Date: 2 August 2022

Application by Medworth CHP Limited for an Order Granting Development Consent for the Medworth Energy from Waste Combined Heat and Power Facility

Advice following issue of decision to accept the application for examination

DRAWING TITLE

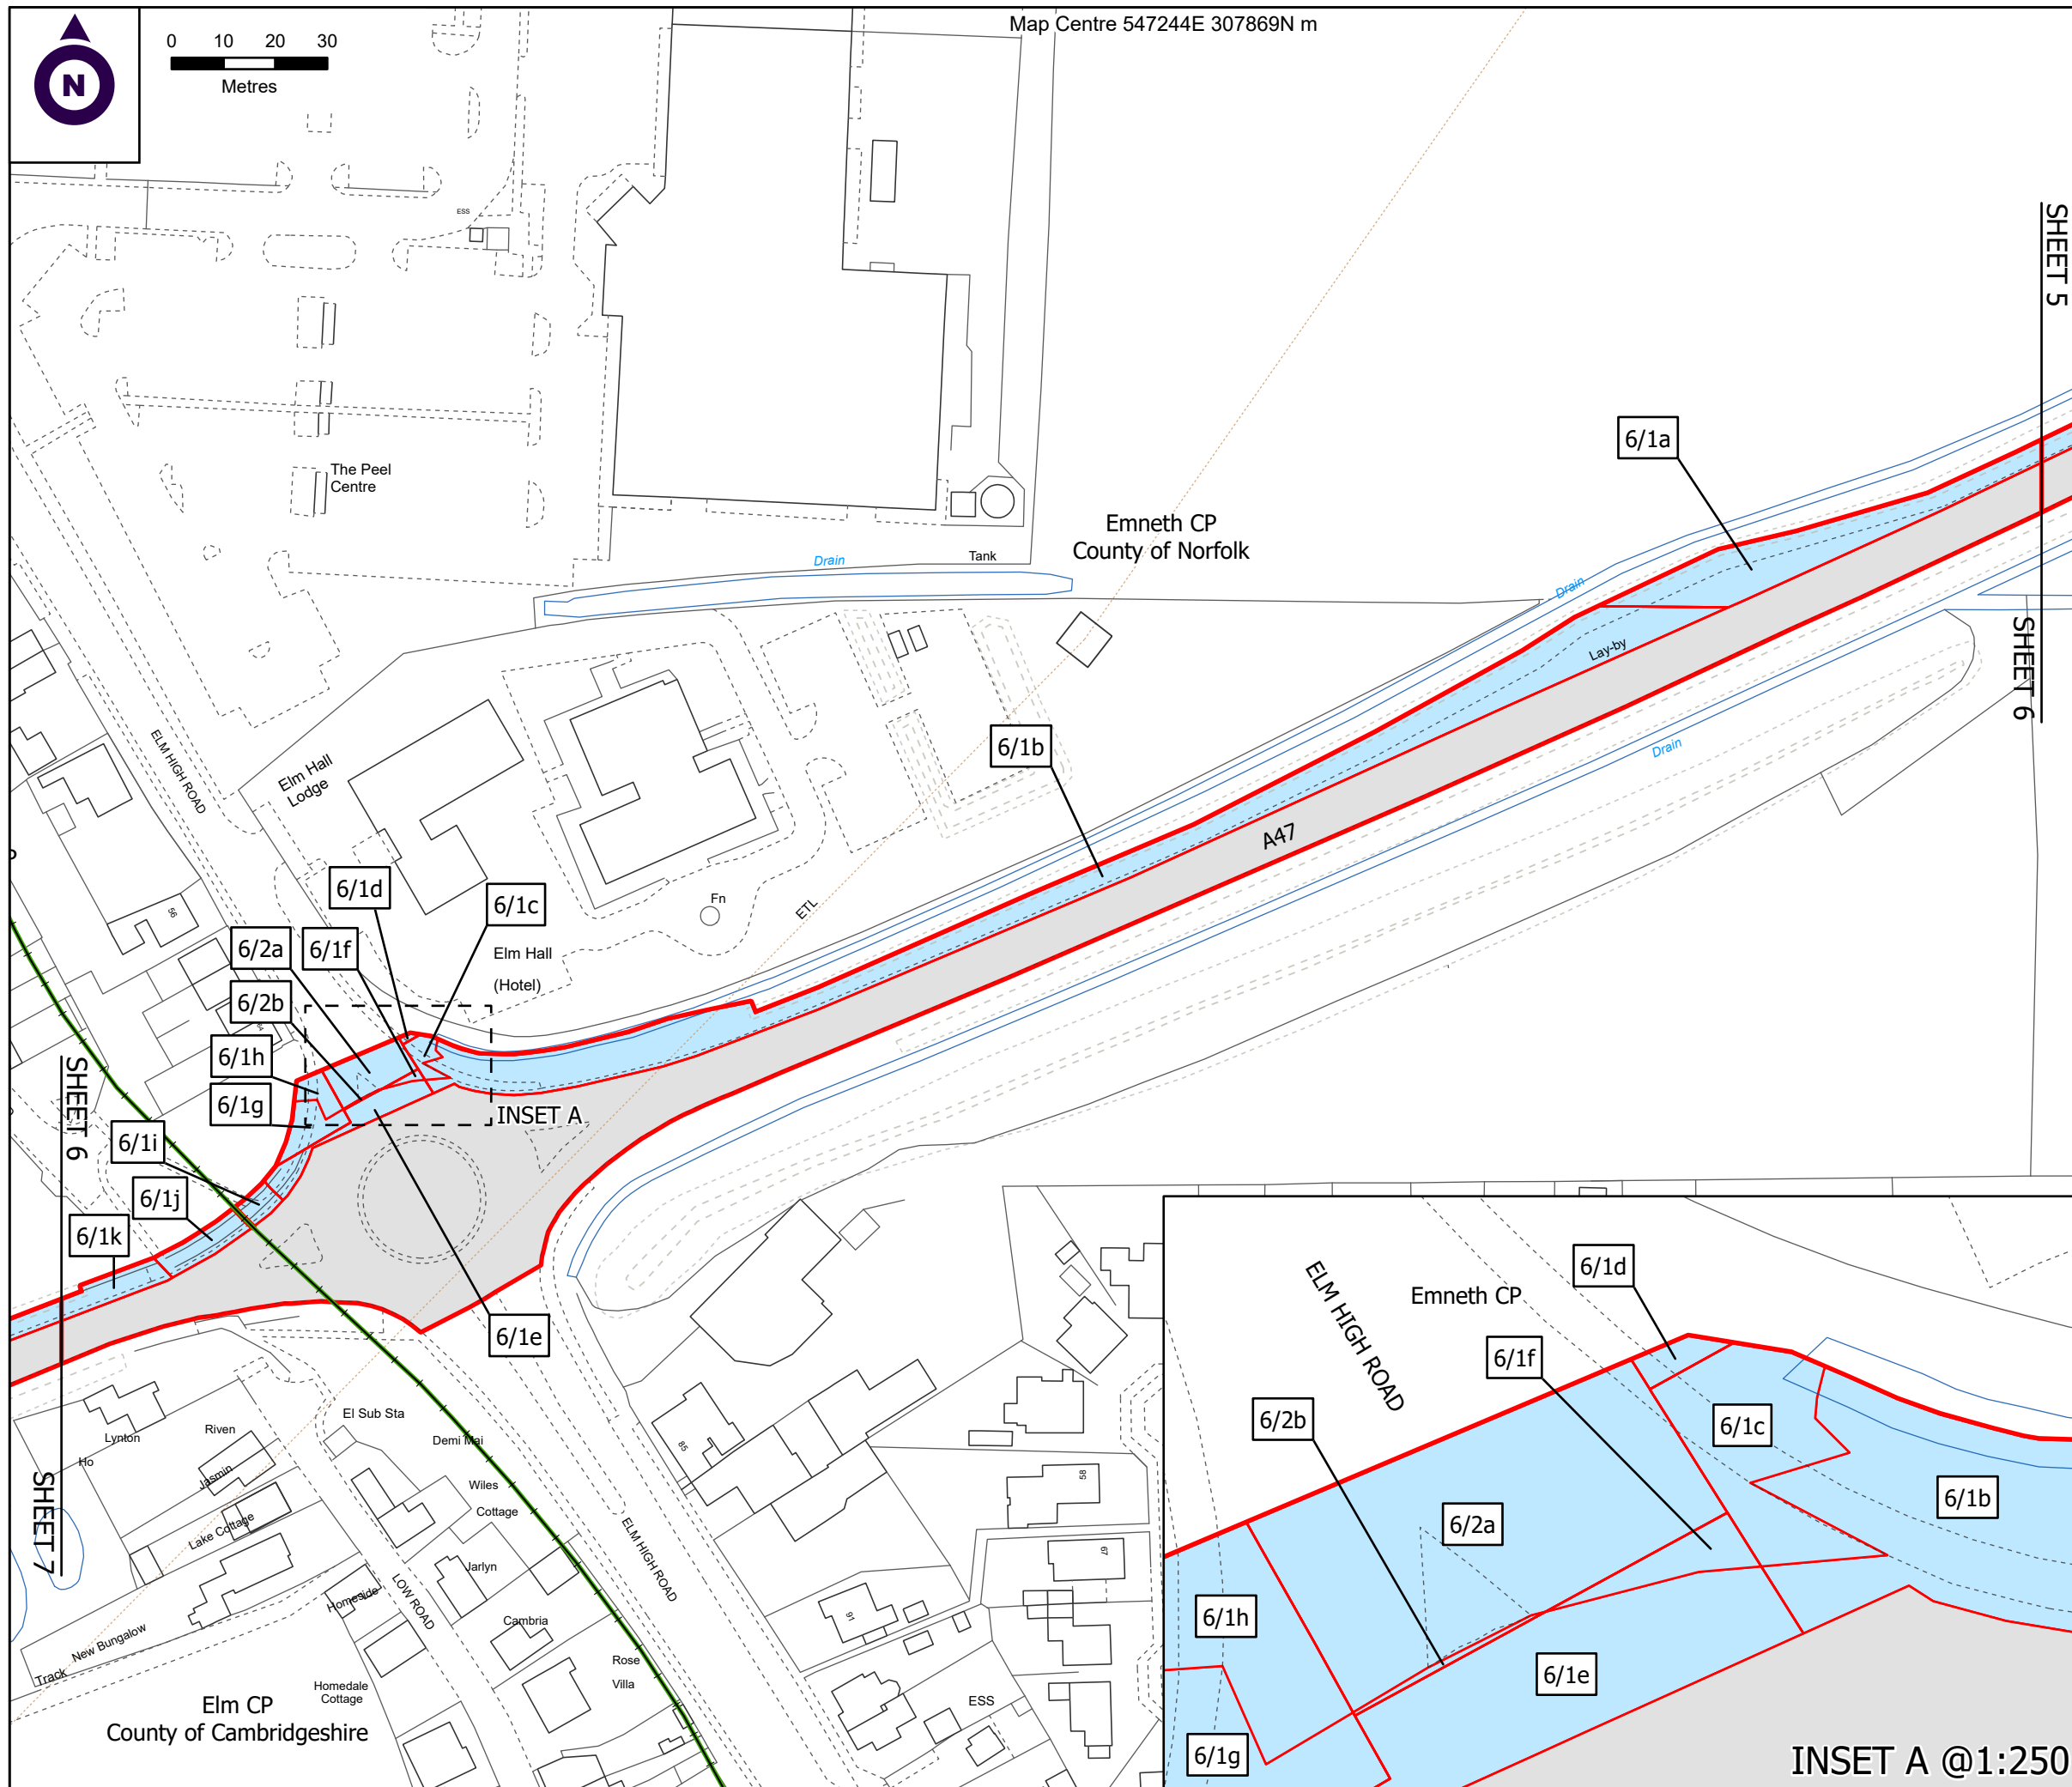
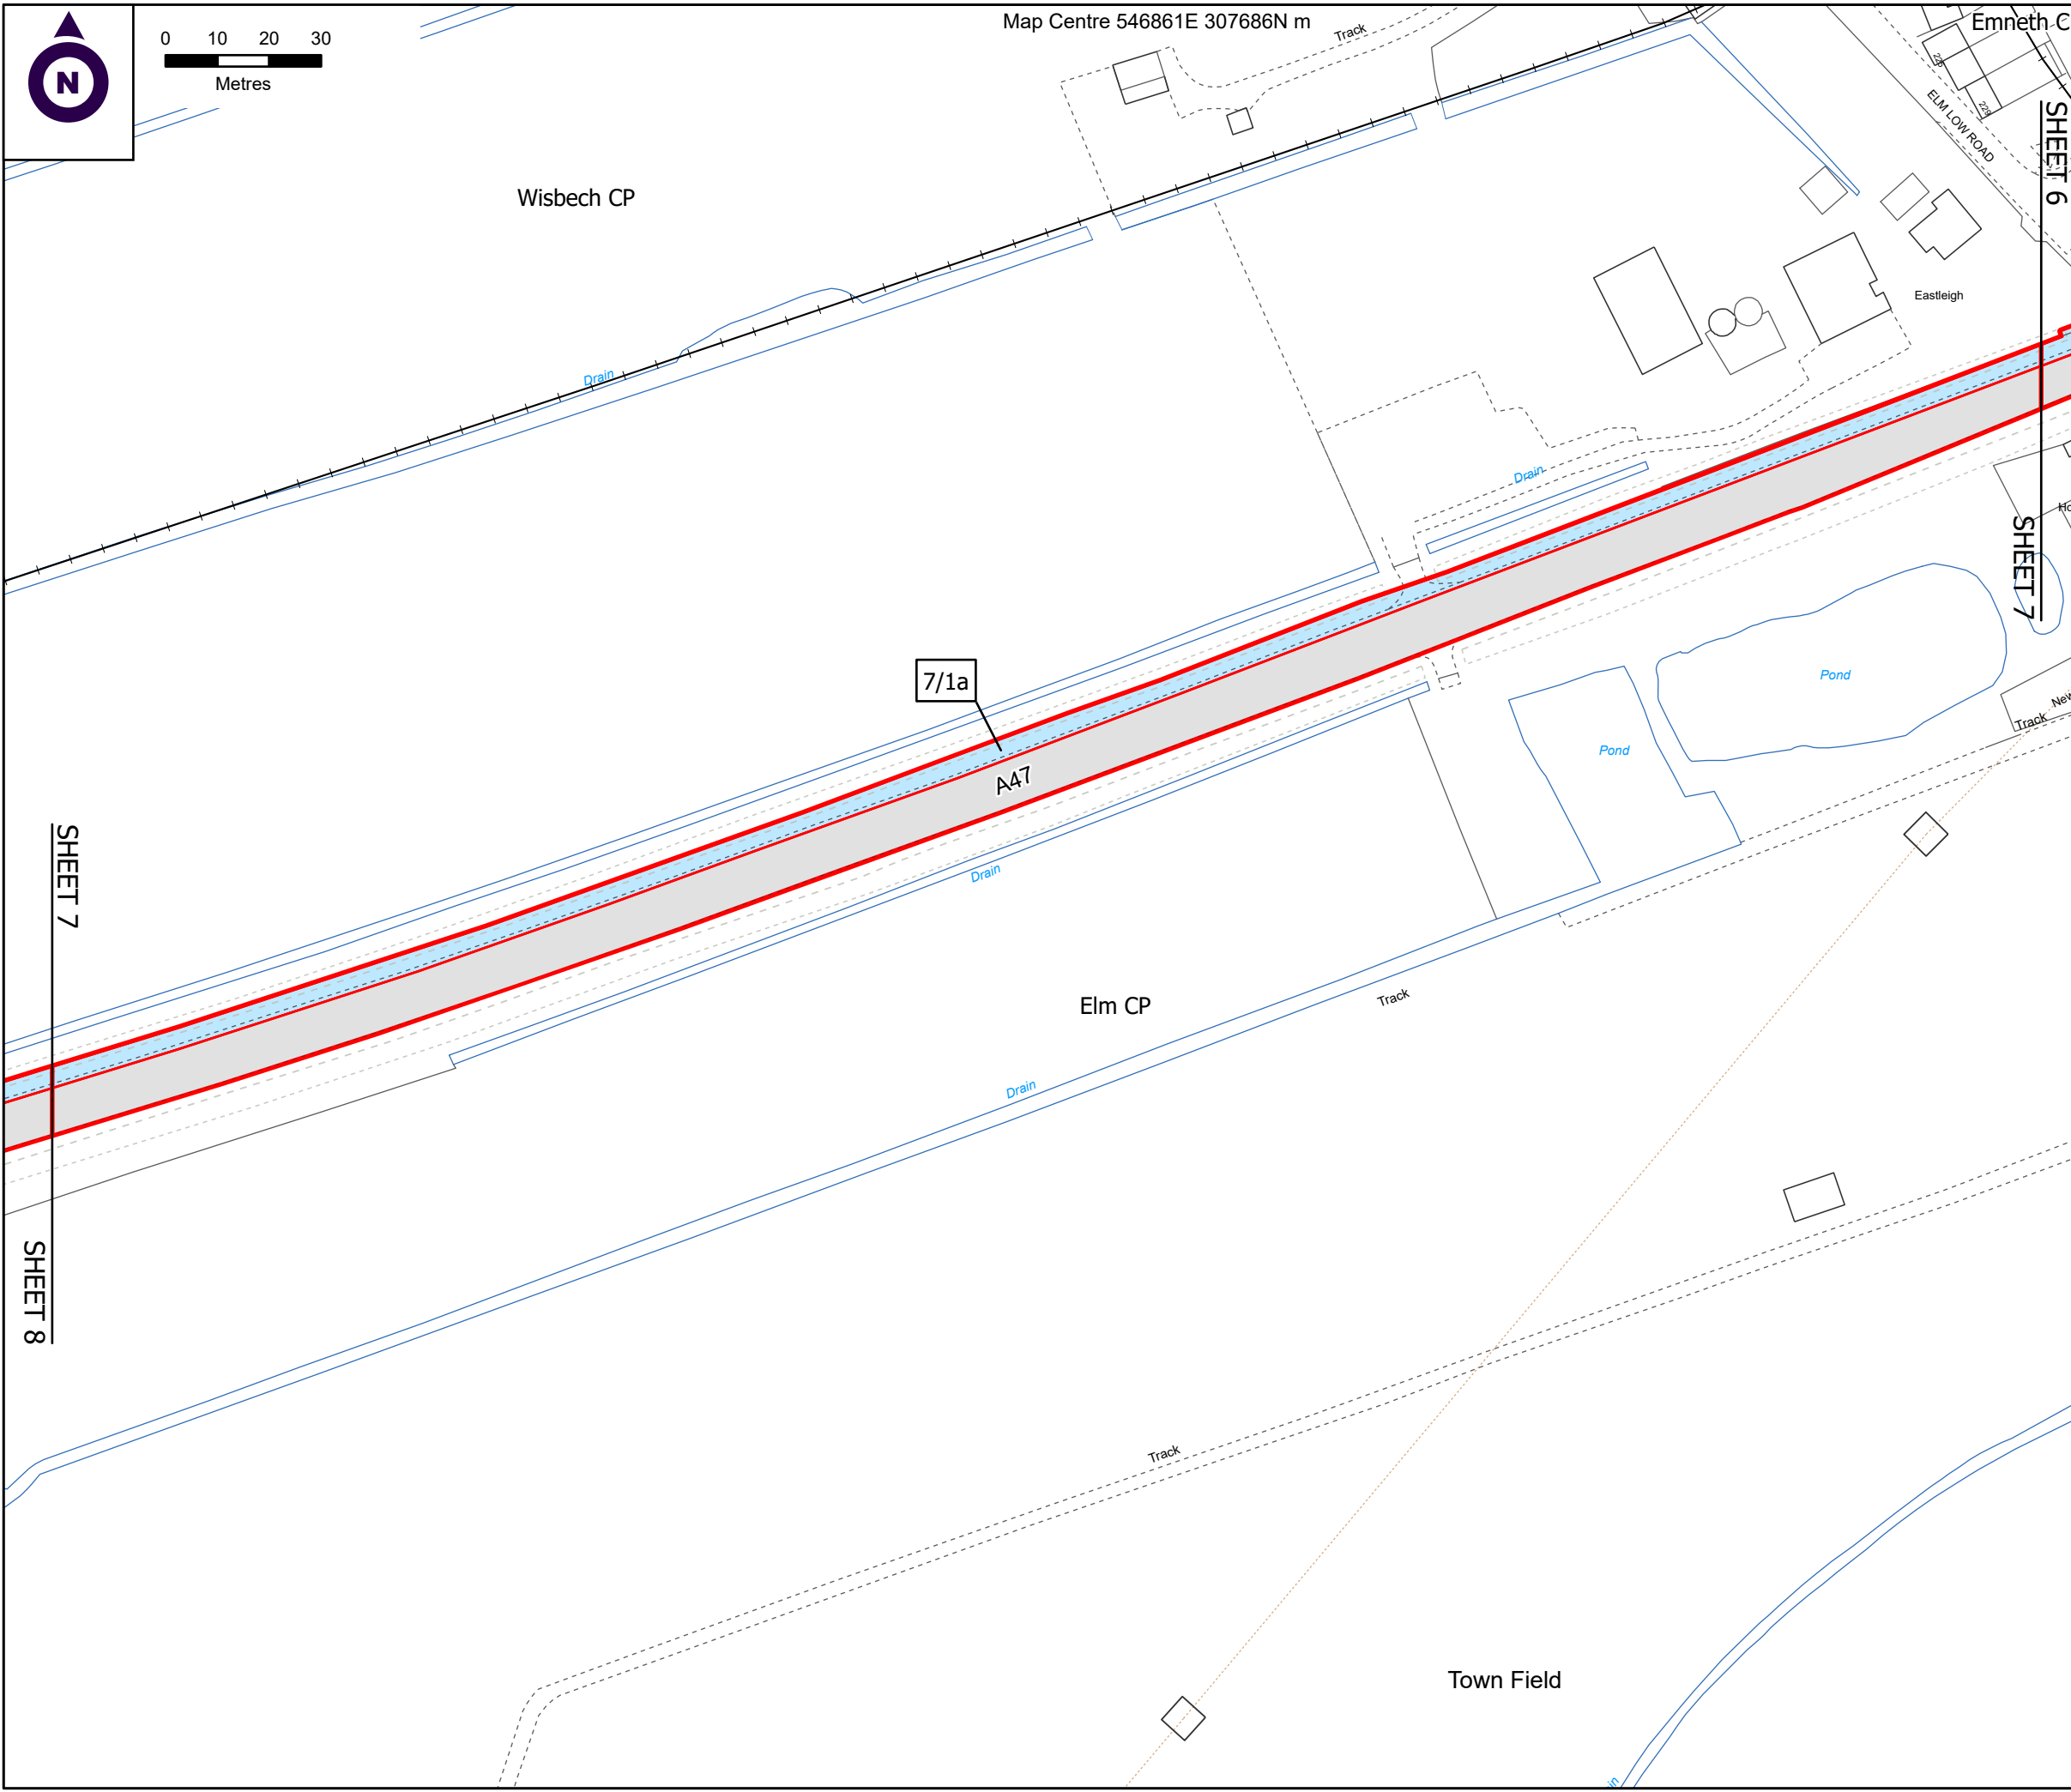
Due to the nature and extent of land affected by the proposal, the **Land Plans (Doc 2.2)** include several plots of land that span more than one sheet. According to the key, each plot must be demarked by a red line. However, for plots that span more than one sheet, this red line, necessary to define the beginning and/or end of a specific plot, is not clearly visible.

In order to enable more meaningful and relevant comments to be made on the application documents, it is suggested that any changes to the **Land Plans (Doc 2.2)** and the **Access**
